Appeal Decision

Appeal Ref: APP/R5510/D/24/3347201

179 Torcross Road, Ruislip, Hillingdon HA4 0TG

- The appeal is made under section 78 of the Town and Country Planning Act 1990 (as amended) against a refusal to grant planning permission.
- The appeal is made by Mr Mohammed Ali against the decision of the Council of the London Borough of Hillingdon.
- The application Ref is 78554/APP/2024/285.
- The development proposed is a loft conversion, a rear extension, a porch and a double storey side extension.

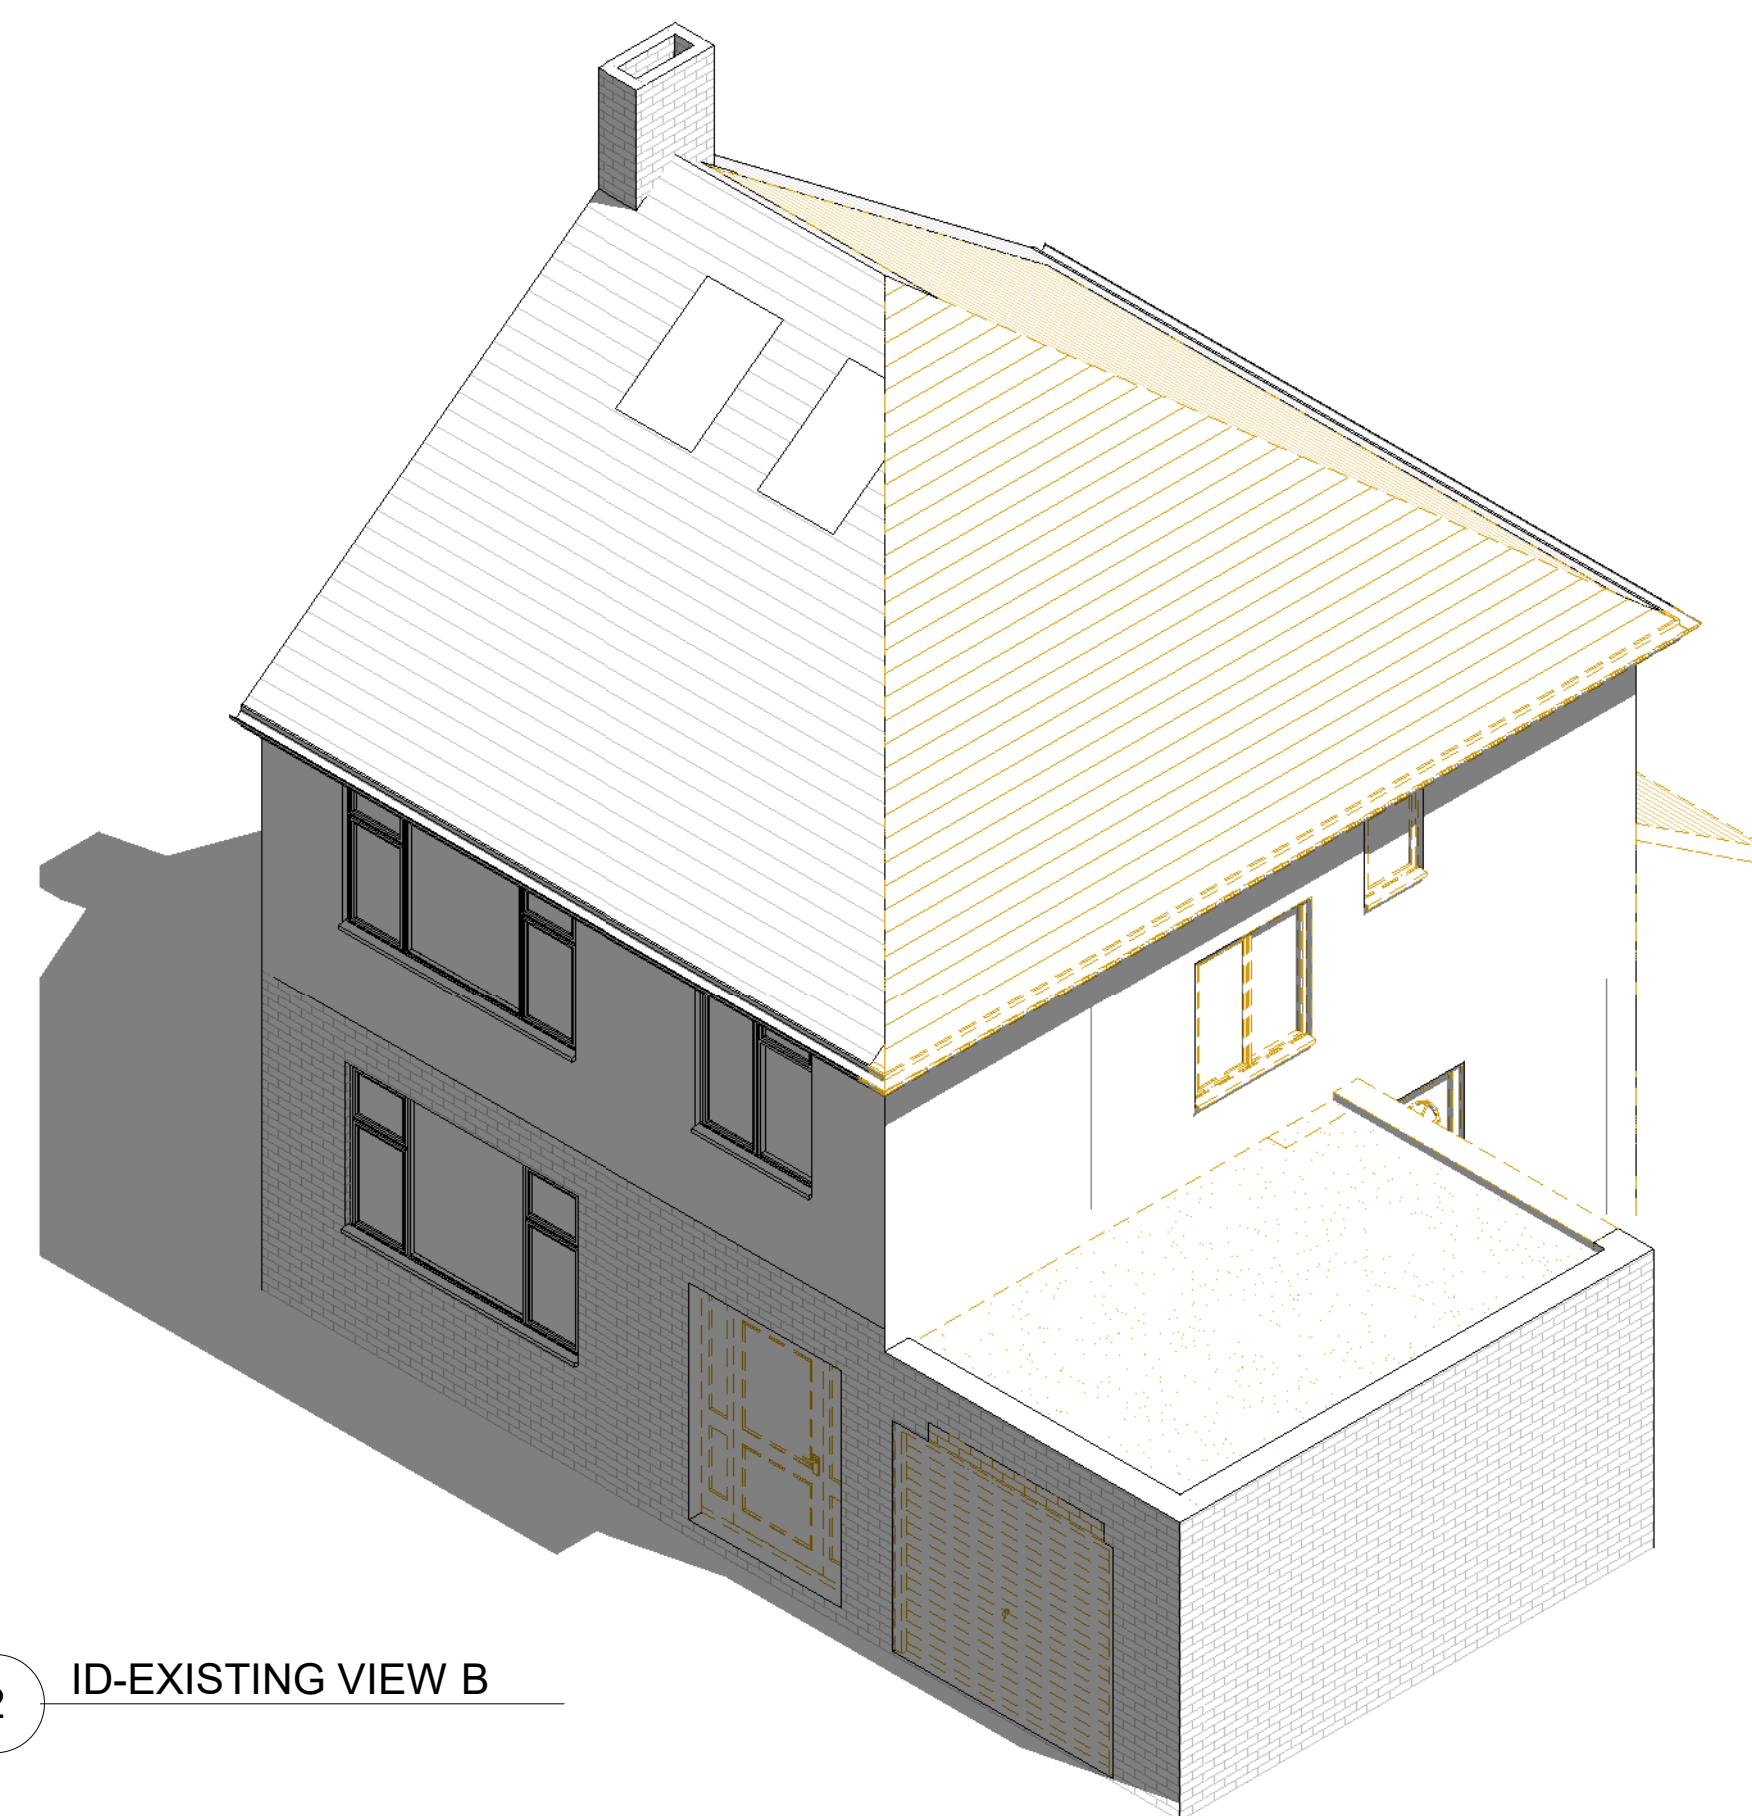
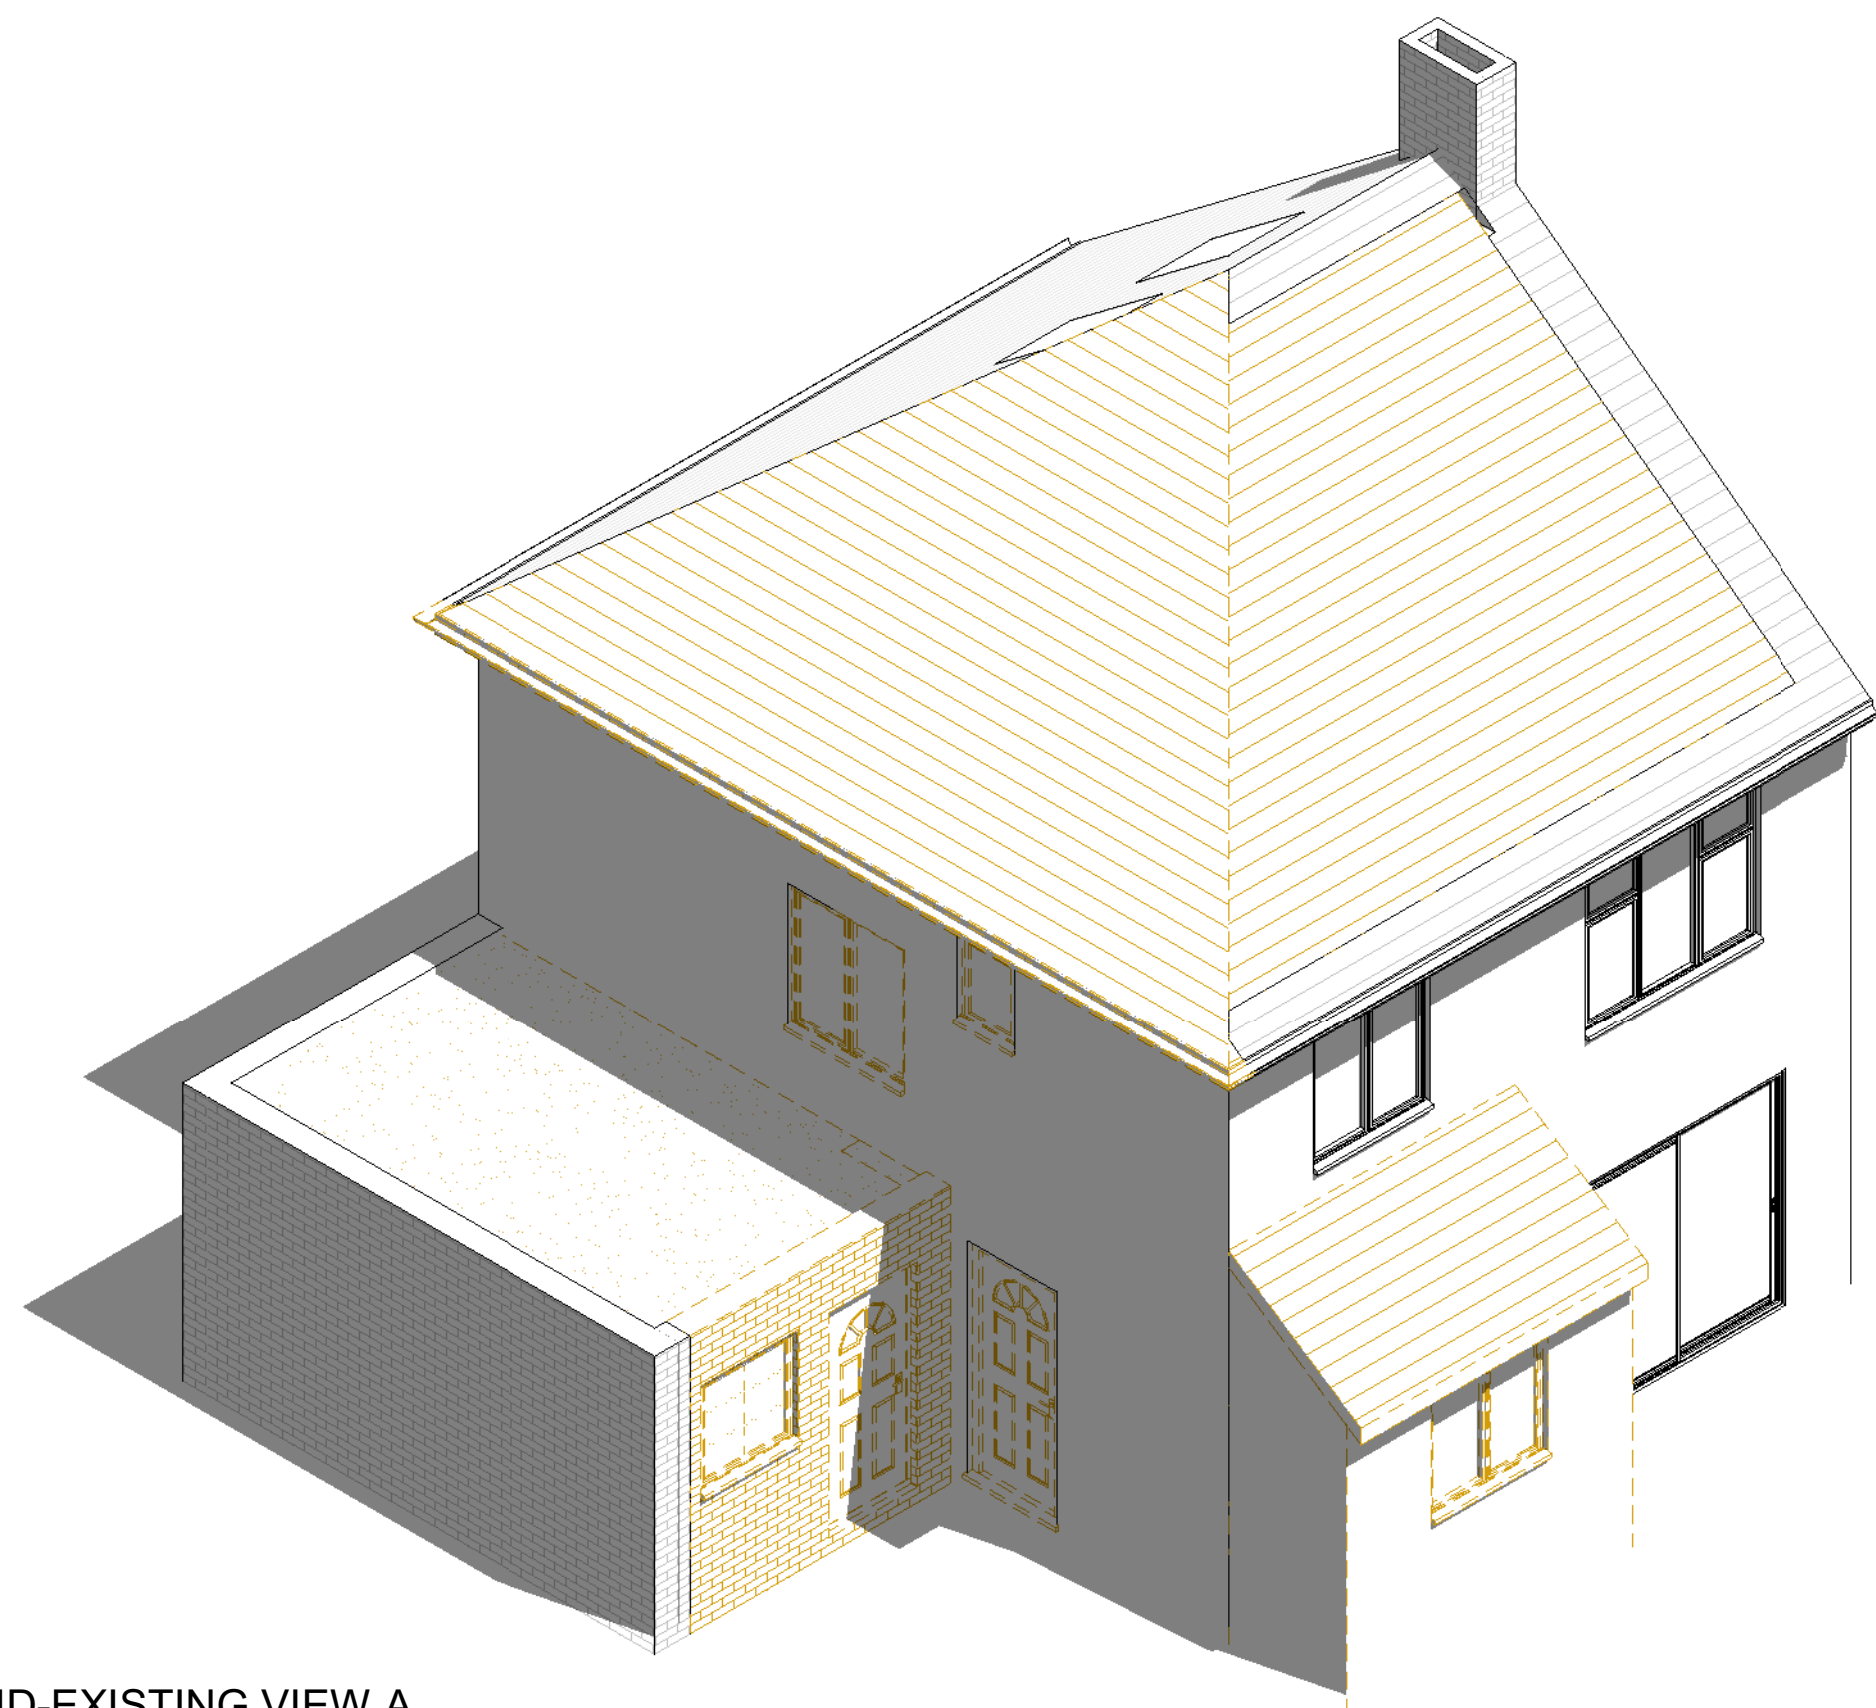
5. The proposed side extension would have a set back front wall at first floor and a set down roof, which would provide a degree of articulation, and ensure that it would have a largely subordinate appearance to the host. However, considered together with the proposed hip to gable conversion, it would unbalance this pair in the streetscene.

6. To the rear, the proposed dormer would cover much of the extended roof from marginally below the host's ridge to just above its eaves. In combination with the proposed side extension, the two storey rear extension, and a single storey

extension, the development would overwhelm the original property, such that very little of its original form, scale and style would still be legible.

7. Viewed from the open space, the resultant property, with its gabled, hipped, and cat-slide roof form, and a substantial flat-roofed dormer, would have a very eclectic appearance. It would be visually complex and awkward, and markedly at odds with No 177, thus causing a significant imbalance in the pair. I have no drawings of the unimplemented planning permission at No 177 (Ref: 77560/APP/2022/2961), but based on the decision notice, that development would be significantly less extensive than proposed here.
